SSD 7009: Marulan South Limestone Mine Continued Operations Project – Response to DPE RFI on Noise Management Plan

Boral submitted the Noise Management Plan (NMP) in accordance with condition B8 of the development consent on 23 March 2022.

The Department of Planning and Environment (DPE) requested further information prior to approving the NMP. DPE's information requests are in **bold** below followed by Boral's response.

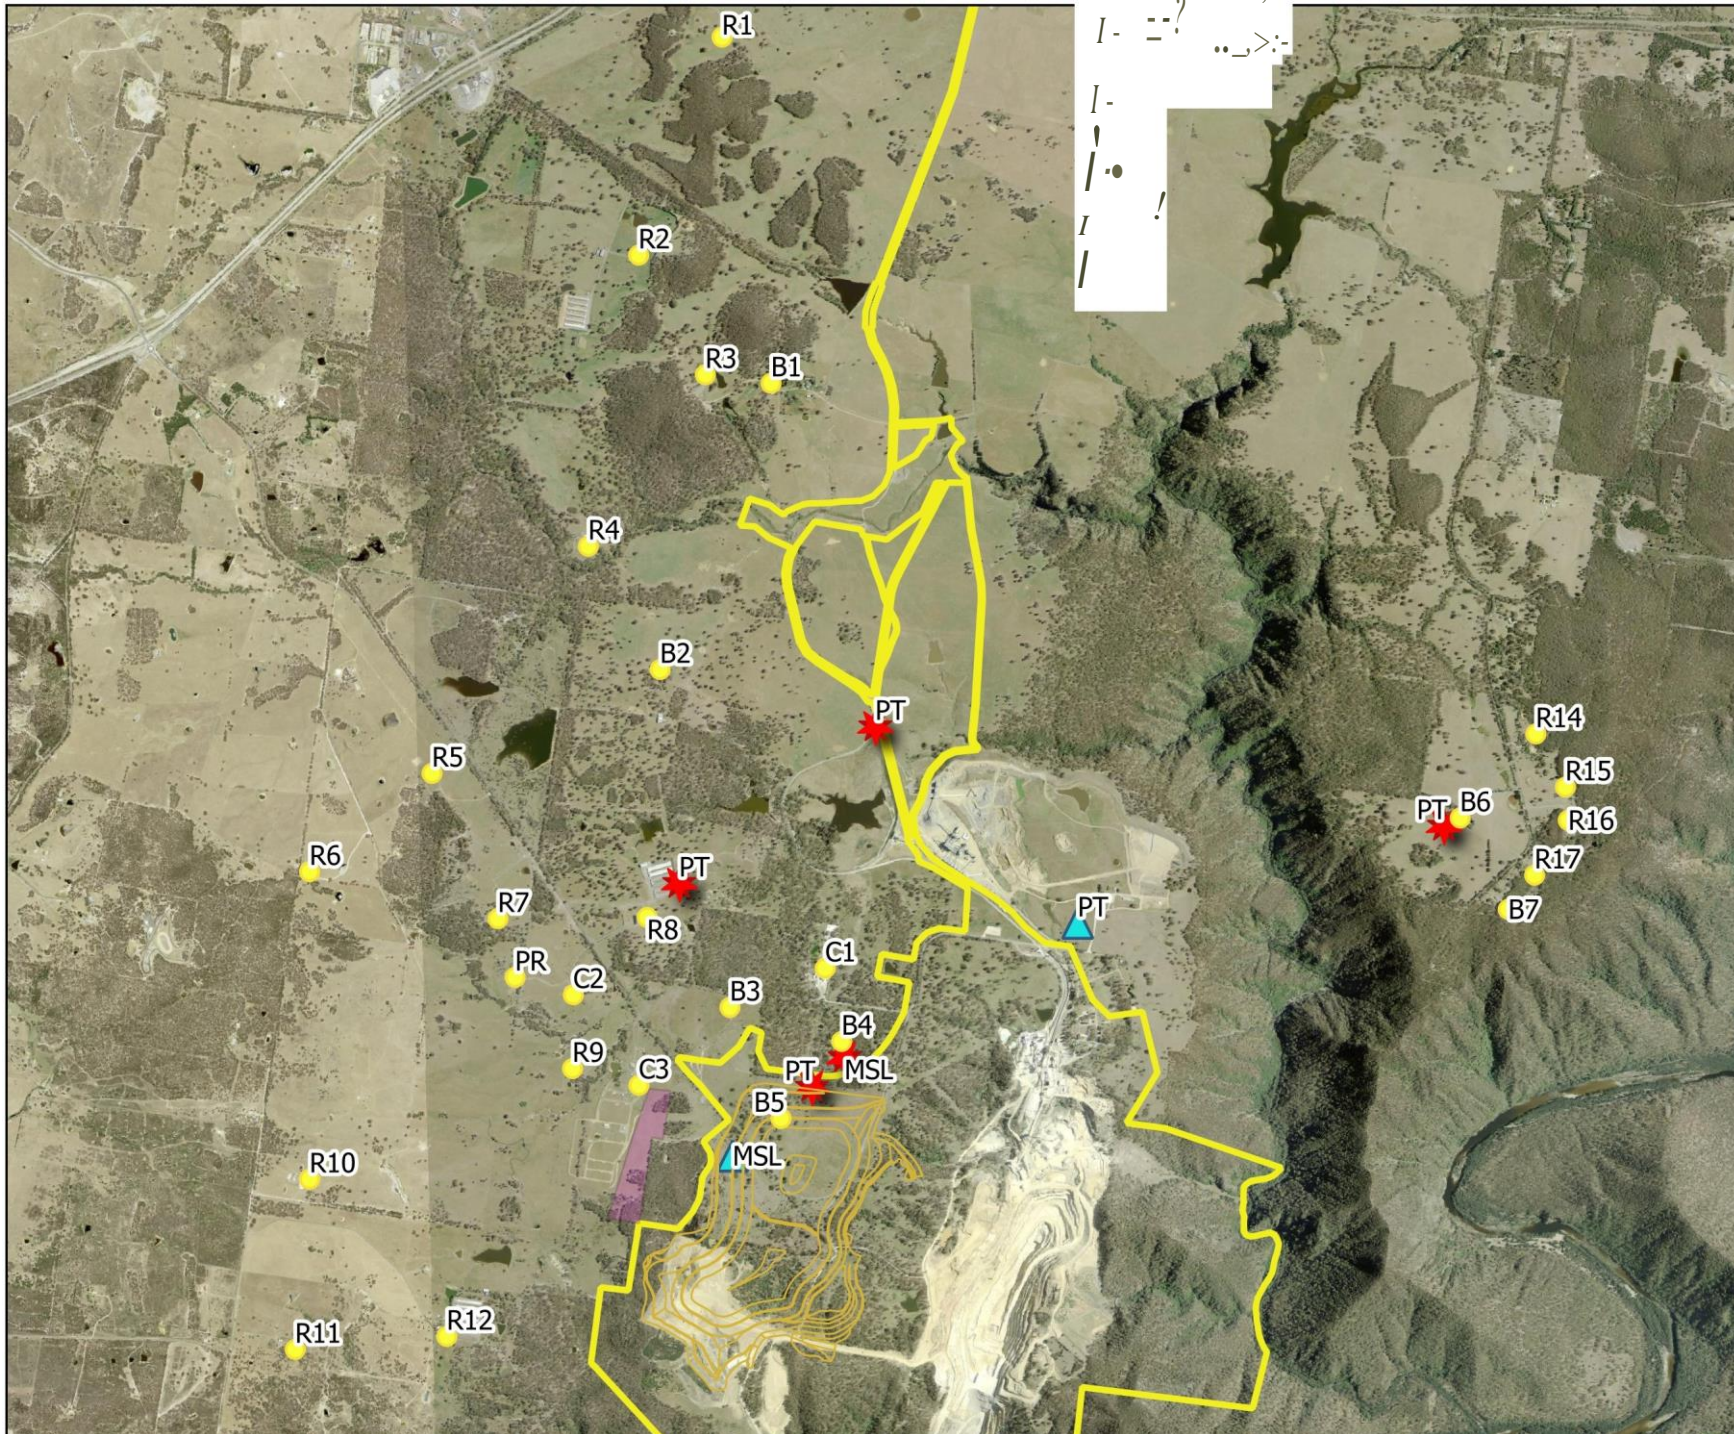
As per condition B7(C) Boral must take all reasonable steps to minimise the noise impacts of the development in noise sensitive areas during the evening and night. Please clarify the location of the Noise Monitoring Terminal (NMT), given it is stated in section 5.1.6 of the management plan the "NMT is situated between the mine and the nearest receiver, R9", whilst figure 5.1 indicates it is within purple shaded area, the "potential NMT location".

The last sentence of the first paragraph of section 5.1.6 of the NMP states: "The NMT will be installed in proximity to the western Project boundary to provide real time noise monitoring data ()".

The fourth paragraph of section 5.1.6 of the NMP states: "As the NMT is situated between the mine and the nearest receiver, R9, to be representative of the criteria at R9, the NMTL is adjusted to account for the difference in distance between R9, the NMT and the mine noise
Figure 5.1 shows a shaded area to the west of the mine's Western Overburden Emplacement (WOE), between this emplacement and the closest receiver R9.

It is therefore clear in the description in the NMP that the proposed NMT will be located to the west of the mines WOE, between this emplacement and the closest receiver R9, within the shaded area. The reason why there is a shaded area and not one specific point for the location of the NMT is that when overburden emplacement activities are taking place in the north-western part of the WOE then the NMT will be moved to the northern section of the shaded area. When overburden emplacement activities are taking place in the south-western part of the WOE then the NMT will be moved to the southern section of the shaded area.

Therefore, we don't believe any amendments are required to the NMP.
